11 April 2024

## **ASPECT INDUSTRIAL ESTATE MODIFICATION 9 (SSD-10448 MOD 6) & STAGE 4 DEVELOPMENT MOD 2 (SSD-60513208) RESPONSE TO REQUEST FOR ADDITIONAL INFORMATION**

Figure 1: Site Plan

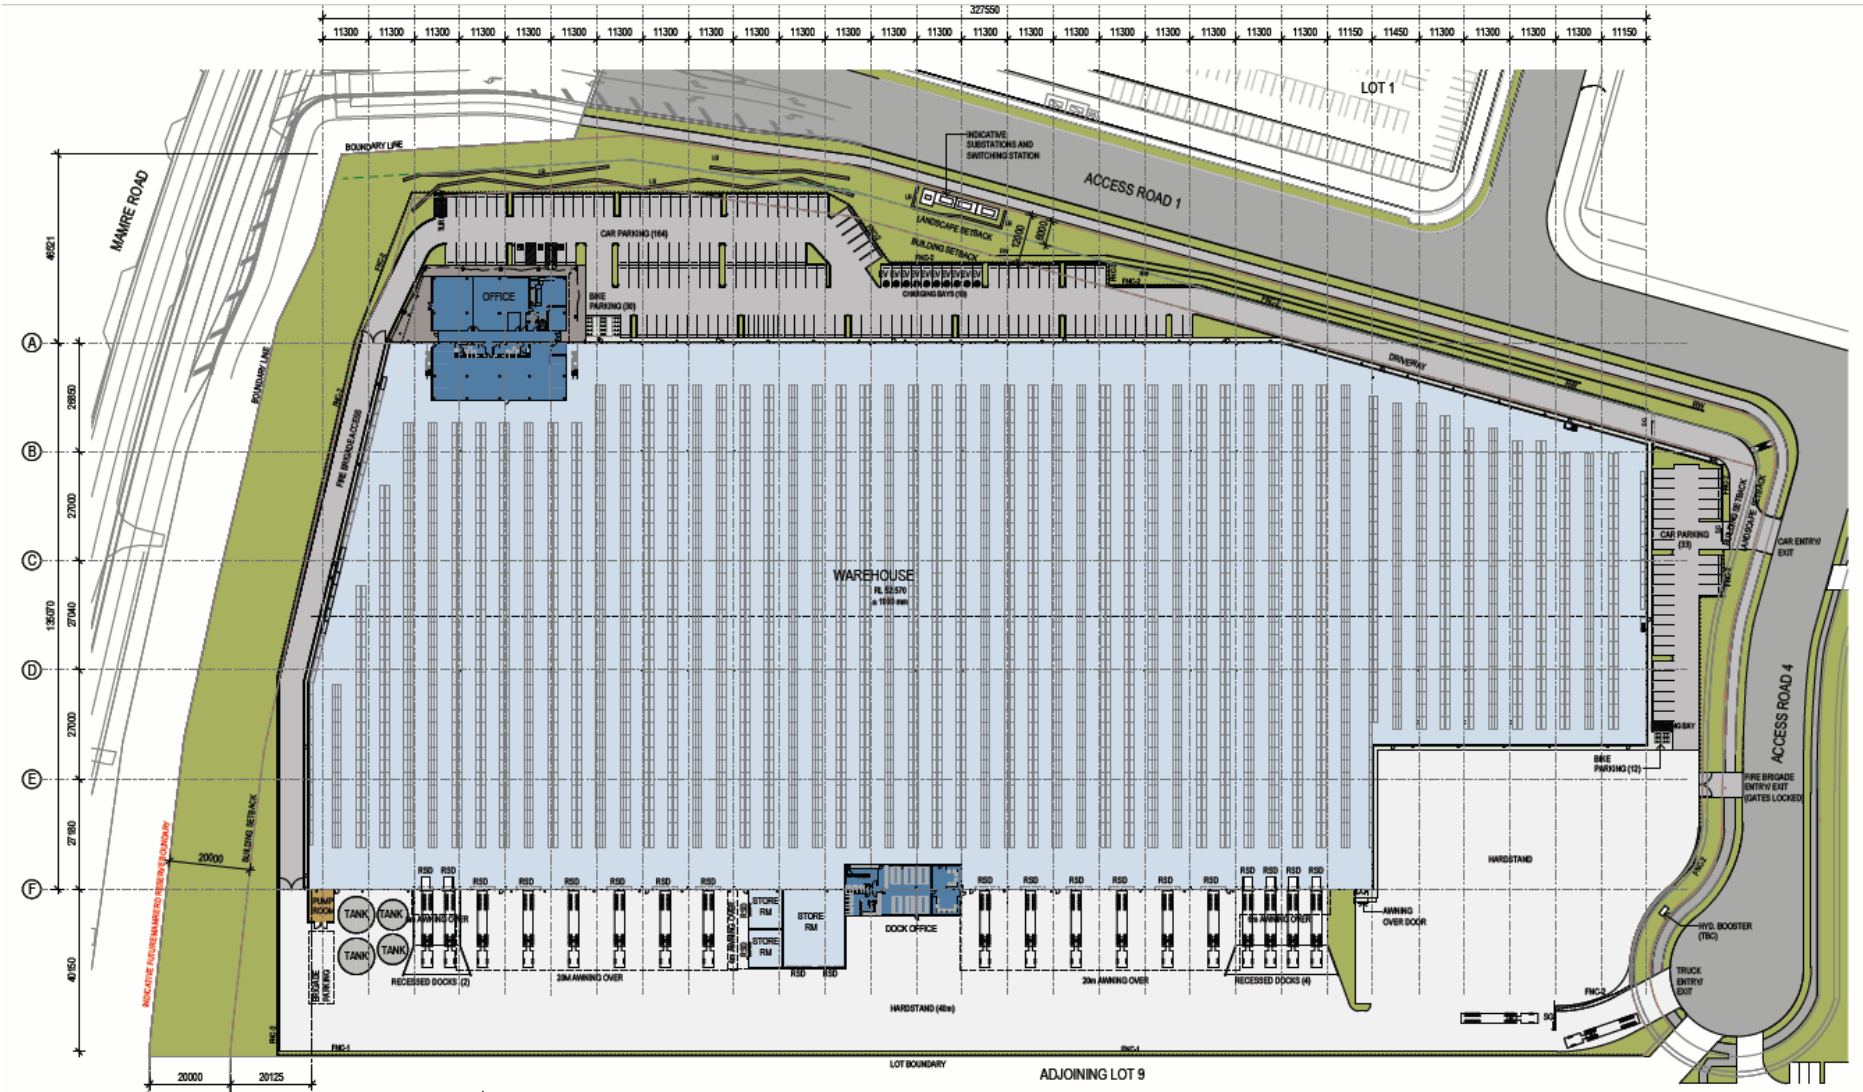
| Summary of Issue Raised   | Response   |
|---|--|
| <p><u>Landscaping</u></p> <p>Penrith City Council has raised concern with the additional 16 car parking spaces for the lot. The additional parking results in a reduction of tree canopy and landscaping and is not supported. Please justify the additional car parking spaces having regard to the MRP DCP.</p> | <p>Refer to Attachment C – Updated Tree Canopy Plan_March 2025.</p> <p>The originally lodged proposal, as detailed in the Modification Report, would have resulted in a minor reduction in tree canopy coverage that would still deliver in excess of the 10% on-lot tree canopy coverage as well as a similar percentage of on-lot landscape area as approved under SSD-60513208. The additional car parking does not encroach into the landscaped setback area.</p> <p>However, fixes to previous errors in the tree canopy coverage drawings (areas that were meant to be included in the tree canopy calculation were incorrectly excluded) have been made. Consequently, the proposal will deliver 11,268.99m<sup>2</sup> on-lot tree canopy coverage, which represents <b>an increase</b> in tree canopy coverage compared to the base approval under SSD-60513208 (which approved 11,255.25m<sup>2</sup> on-lot tree canopy coverage).</p> <p>With regard to landscape area, the proposal will deliver 10,063m<sup>2</sup> of landscaped area (representing 13.29% of the site area) which is similar to the 13.5% landscape area approved under the original consent in response to the 15% requirement under the MRP DCP.</p> <p>Additionally, as raised by Council below, the proposal (MOD-2 to Warehouse 8 and MOD-9 to SSD-10448) should be considered in conjunction with the concurrent applications for the intended future tenant use at Warehouse / Lot 8 (under the separate MOD-10 of SSD-10448 and SSD-80331959 applications). MOD-10 of SSD-10448 and SSD-80331959 intends to convert the hardstand area in the eastern portion of the site into at-grade carparking with supporting landscape / tree islands. As such, the tree canopy coverage and landscape areas are anticipated to see further increases as part of intended development outcome.</p> |
| <p><u>Substation</u></p> <p>It is noted that the modification proposes to locate the substation within the building setback to comply with Condition B.37(e) of</p>   | <p>The location of the substation at Warehouse / Lot 8 fronting Access Road 1 has been updated to be located adjacent to Access Road 1 within the landscape setback. The revised location has been prepared to comply with Endeavour Energy's (<b>EE</b>) construction standards under MCI006, ensuring the substation has 24 hour a day employee and vehicle access directly from a public street and ensuring there is no reduction in landscaping fronting Access Road 1.</p>   |

SSD-60513208. The architectural plans indicate the substation is located within the building setback along the northern elevation of the lot fronting Access Road 1. However, it has been brought to the Department's attention that design changes would be required to ensure compliance with Endeavour Energy's access requirements. This would result in a reduction in landscaping fronting Access Road 1 and is not supported by the Department. The Applicant is required to update the architectural plans to show the substation located adjacent to Access Road 1 within the landscape setback. The Applicant must update any conditions which are to be revised in regard to the location of the substation.

Figure 2: Elevations

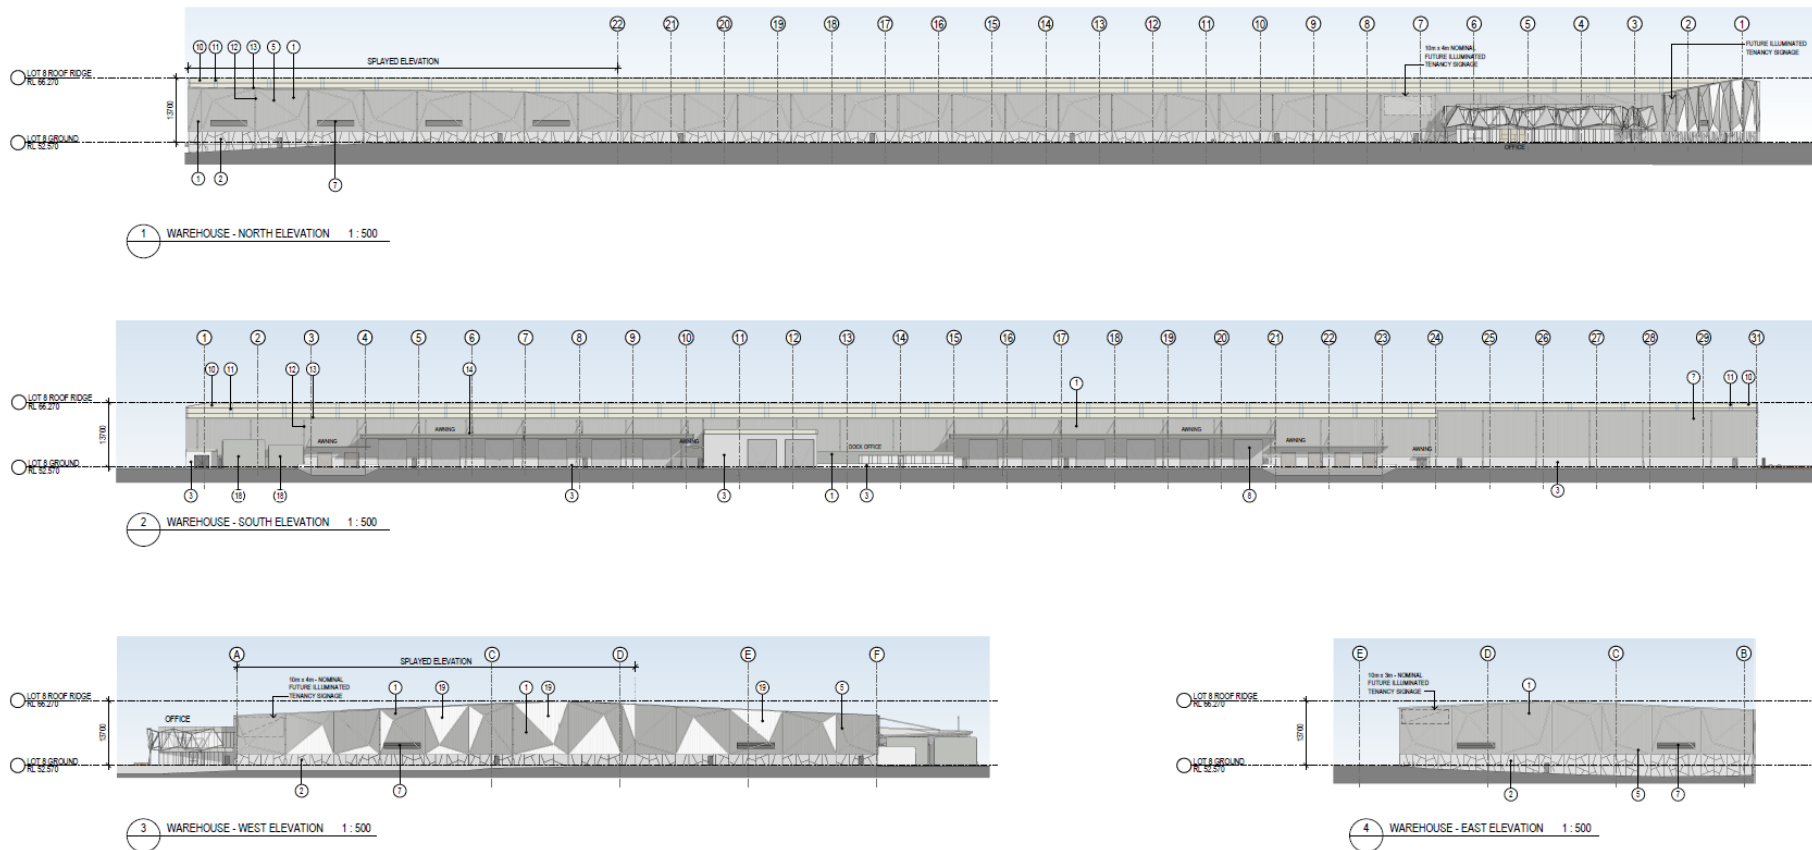
| Summary of Issue Raised   | Response   |
|---|--|
| <p>The LED lighting strip proposed along the western elevation is not supported by the Department and Condition A13 of SSD-60513208 was imposed to remove this. Please update the architectural plans to remove the LED lighting.</p> | <p>Refer to Attachment A – Updated Architectural Drawings_April 2025. The updated architectural drawings remove the LED lighting strip along the western elevation.</p>  |
| <p>Penrith Council raises concern with the location and length of the 50 m long sign on the northern façade of Warehouse 8. The</p>   | <p>The scale of the building identification signs have been updated as follows:</p> <ul style="list-style-type: none"> <li>▪ North Elevation sign: reduction in dimension from 50m x 3m to 10m x 4m</li> </ul>   |

| Summary of Issue Raised   | Response   |
|---|--|
| <p>location of the sign along the northern facade is to be reduced in length and located in a position that does not conflict with the decorative architectural facade detailing feature and is not visually dominant when viewed from Mamre Road.</p>  | <p>The reduced signage dimensions mitigates any conflict with the decorative architectural facade detailing feature and ensures that it does not dominate the view from Mamre Road.</p> <p>Refer to Attachment A – Updated Architectural Drawings_April 2025</p>   |

| Summary of Issue Raised  | Response  |
|--|---|
| <p>The new proposed sign on the northern warehouse elevation is very large (50m long). It appears to be conflicting and will obscure some of the decorative architectural facade detailing. The other approved building identification walls signs are 10m long and 22m long, which is much smaller than the proposed new sign. If the Department are of a mind to approve this signage, please consider whether</p> | <p>Refer to the response to DPFI's comment in the rows of this table above on the changes to the reduction to the north elevation sign dimensions. Additionally, in response to Council's comment the West Elevation sign has reduced dimensions from 22m x 3m to 10m x 4m</p> <p>Refer to Attachment A – Updated Architectural Drawings_April 2025</p> |
